H16-0552-26

Care Home Development off Shakespeare Way, Spalding

Client:	Country Court Care
Project Title:	Proposed care development at land off Shakespeare Way, Lincolnshire, PE11 1GU
Drawing Title:	Proposed Site Plan
Status:	STAGE 3
Date:	05.06.2026

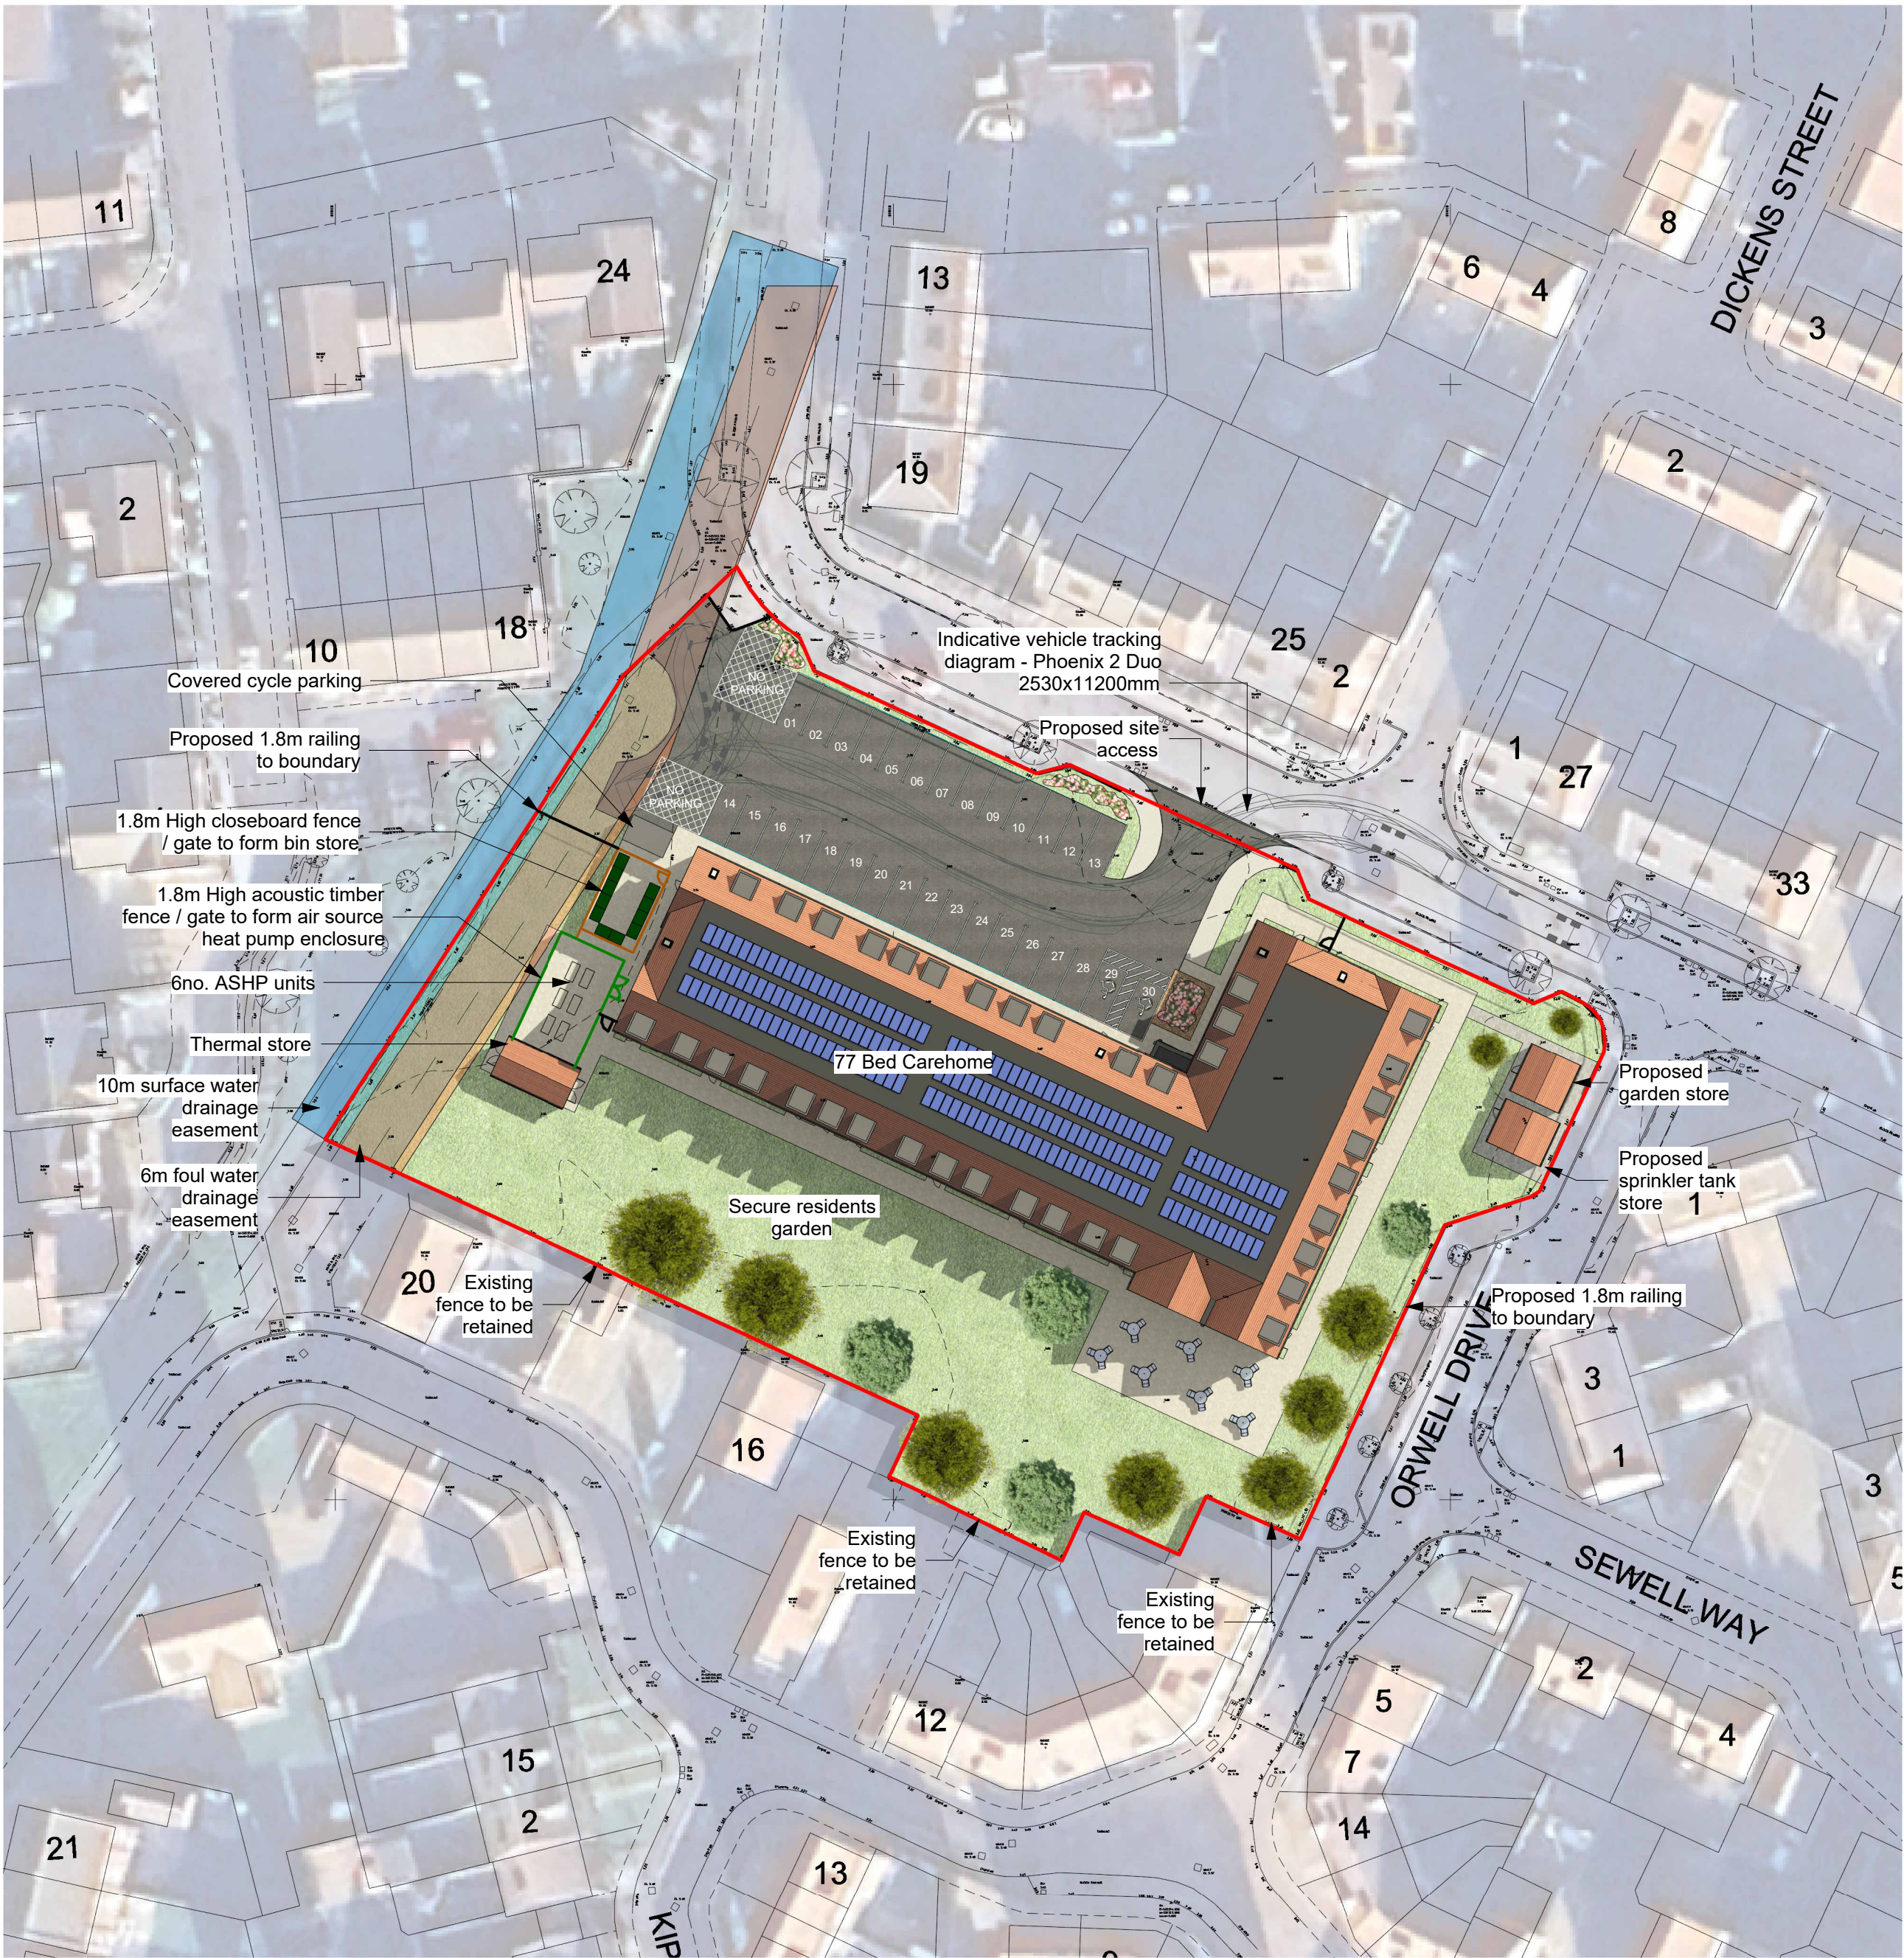
Nearby residents are concerned about the increase in traffic movements on residential roads, along with safety concerns about visibility as there is a 90 degree blind bend at Ambassador Walk within 50 yards of the proposed vehicular entrance. In addition, the entrance does not appear wide enough to allow vehicles to enter and exit safely.
